# CITY OF PORTLAND BUILDING PERMIT

**PERMIT ID:** 2012-65702

86 Commercial St - 6 Custom House Wharf

has permission to **Interior renovations for new restaurant 1st & 2nd floors (change of use for 2nd floor), including structural upgrades to beams, columns & wharf bents and 2nd floor exterior deck w/outside dining on both decks (internal demo permit #2012-10-5242)**

SECTION 2
 1 1/2" = 1'-0"

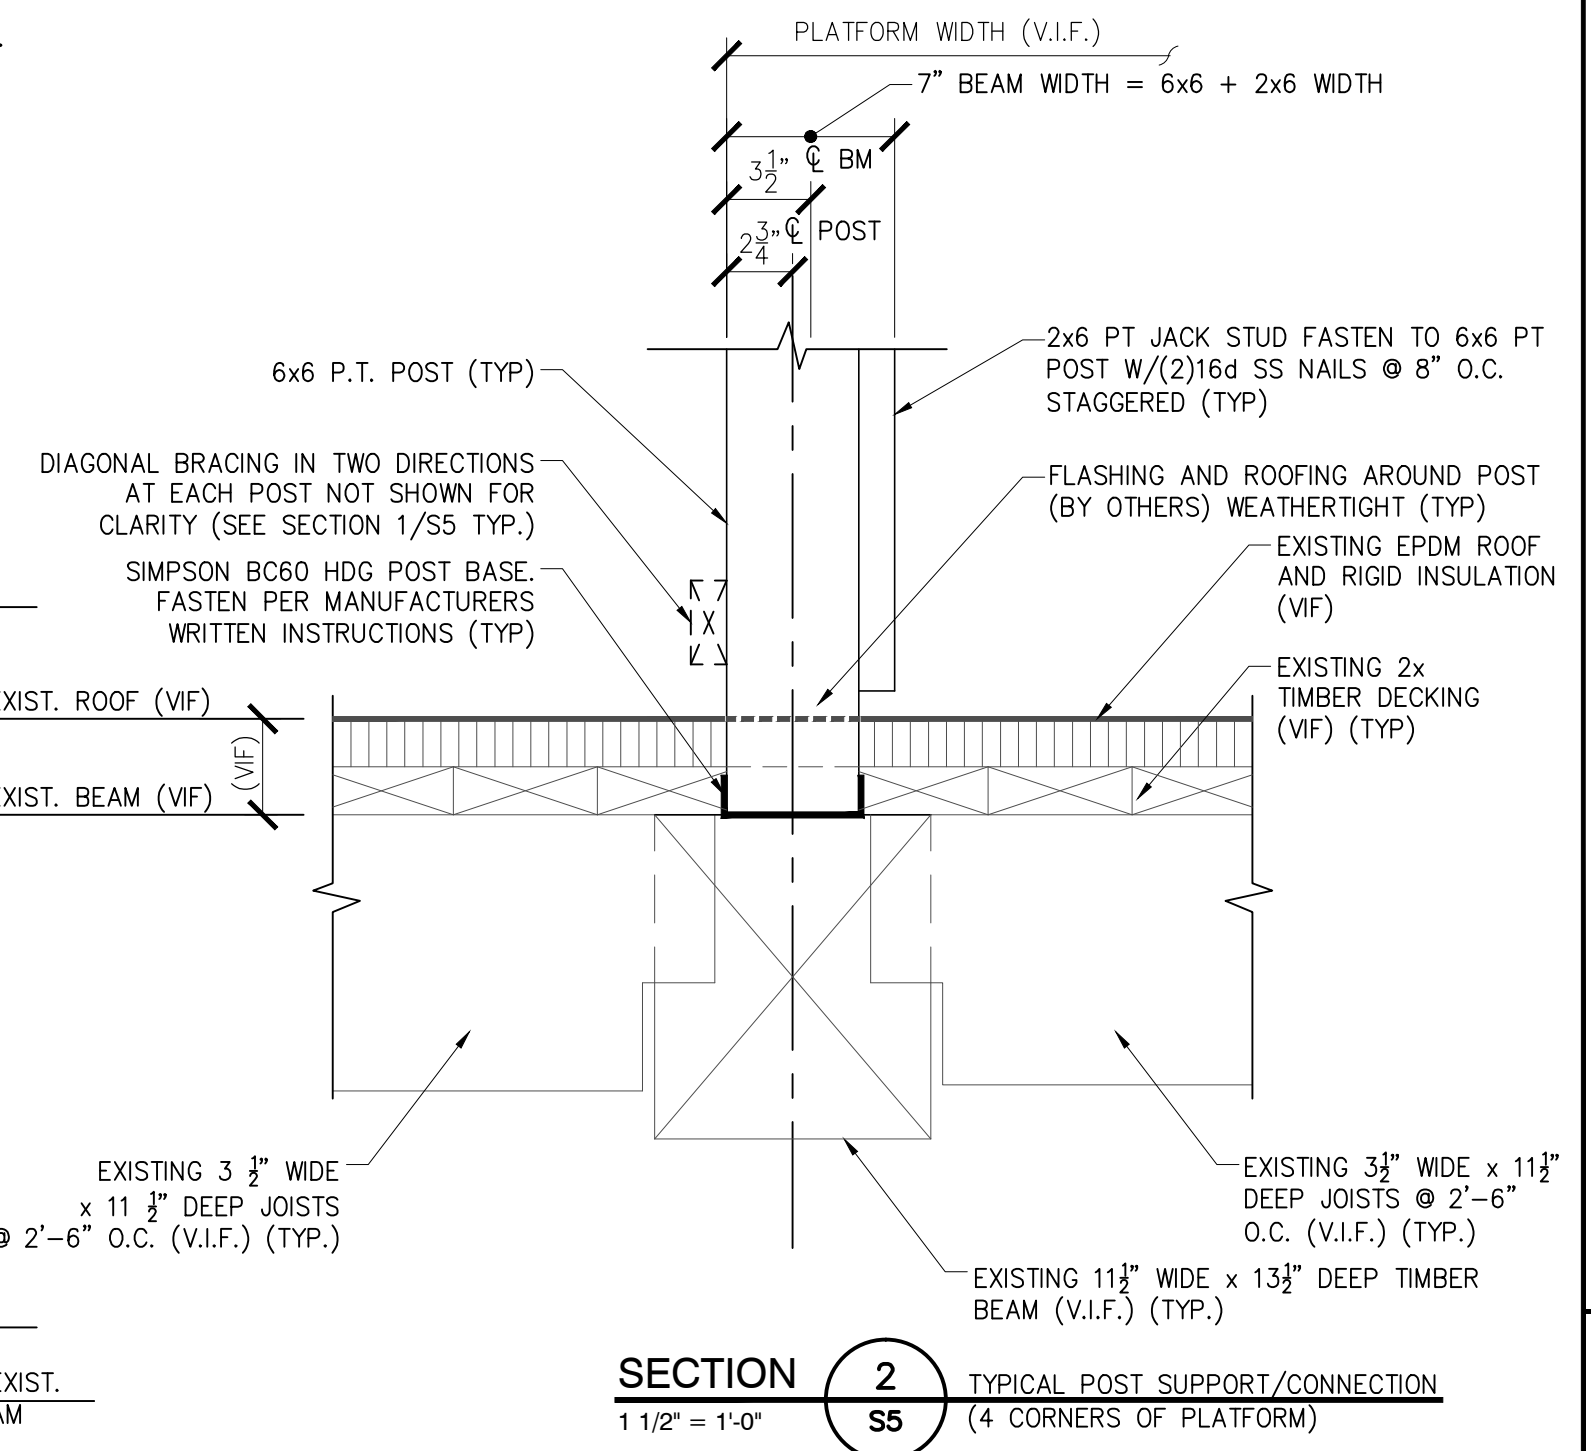
- 11) Framing/structural details for the rooftop platform for the HVAC equipment shall be submitted for review prior to commencement of this work.

2 Second Floor Plan

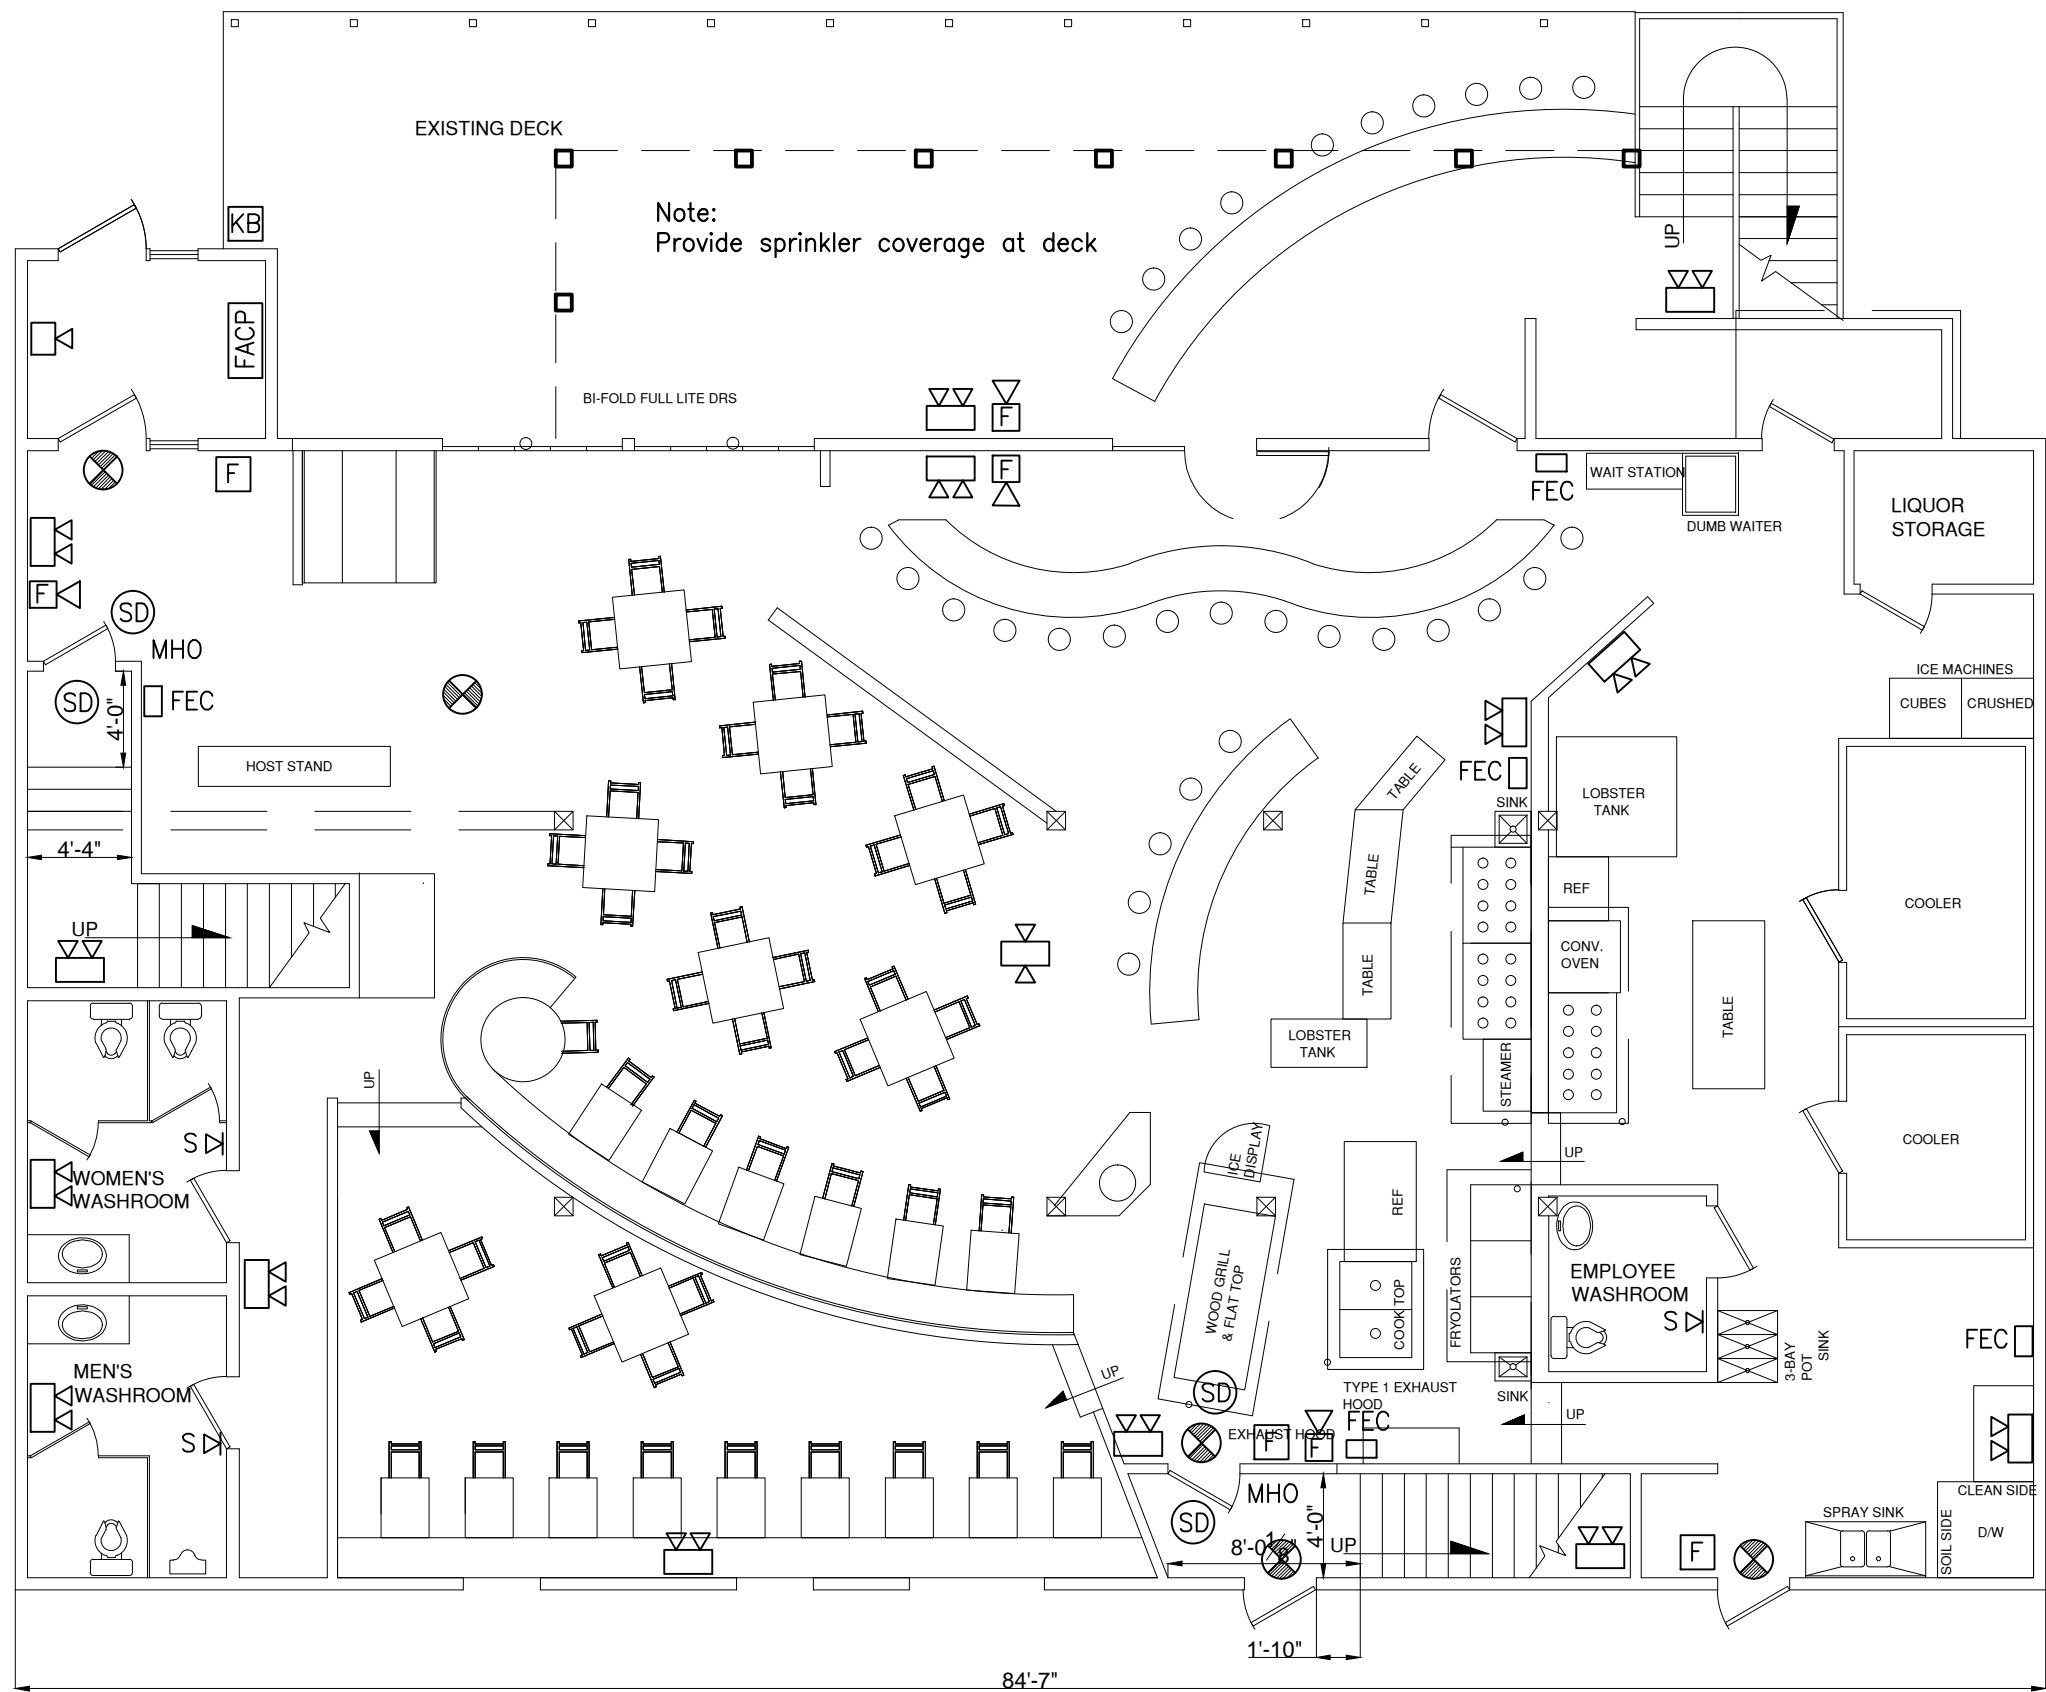
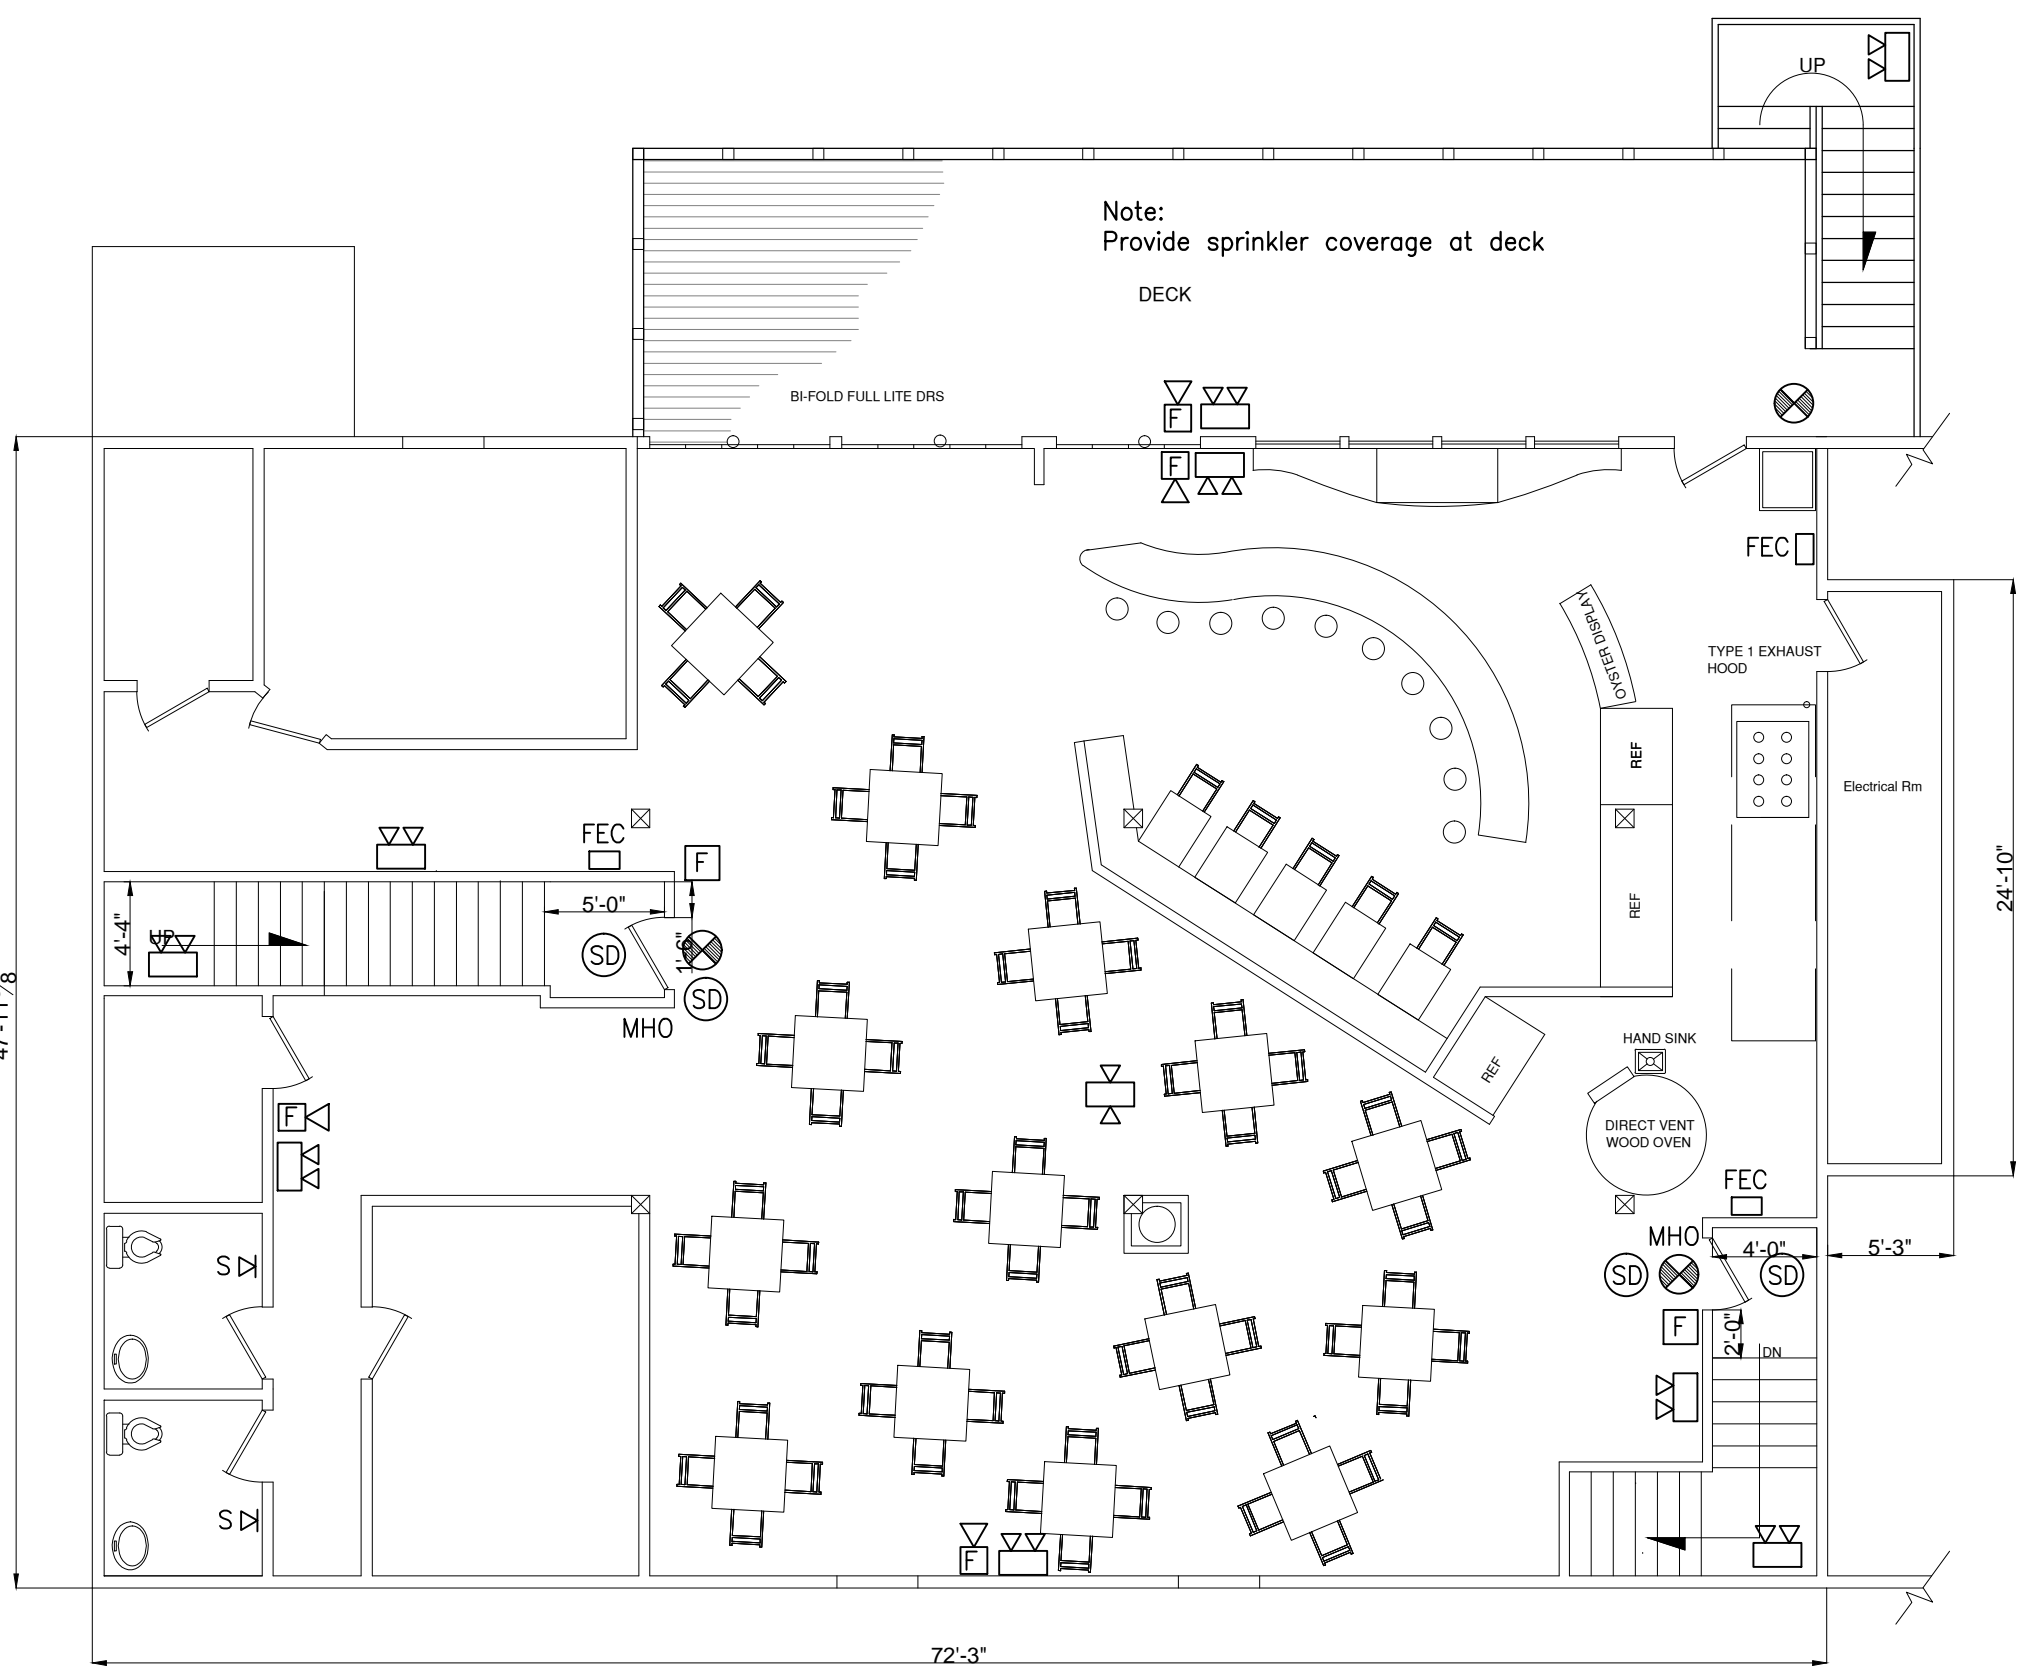
4. The second floor bathroom hallway exceeds the 20 ft. common path and dead end corridor requirement of the *Life Safety Code*. Please amend the arrangement to keep within the 20 ft. for both requirements.

The second floor toilet room hallway was revised by adding steps down to the seating area so we do not have a dead end corridor situation anymore, refer to ASK.06.
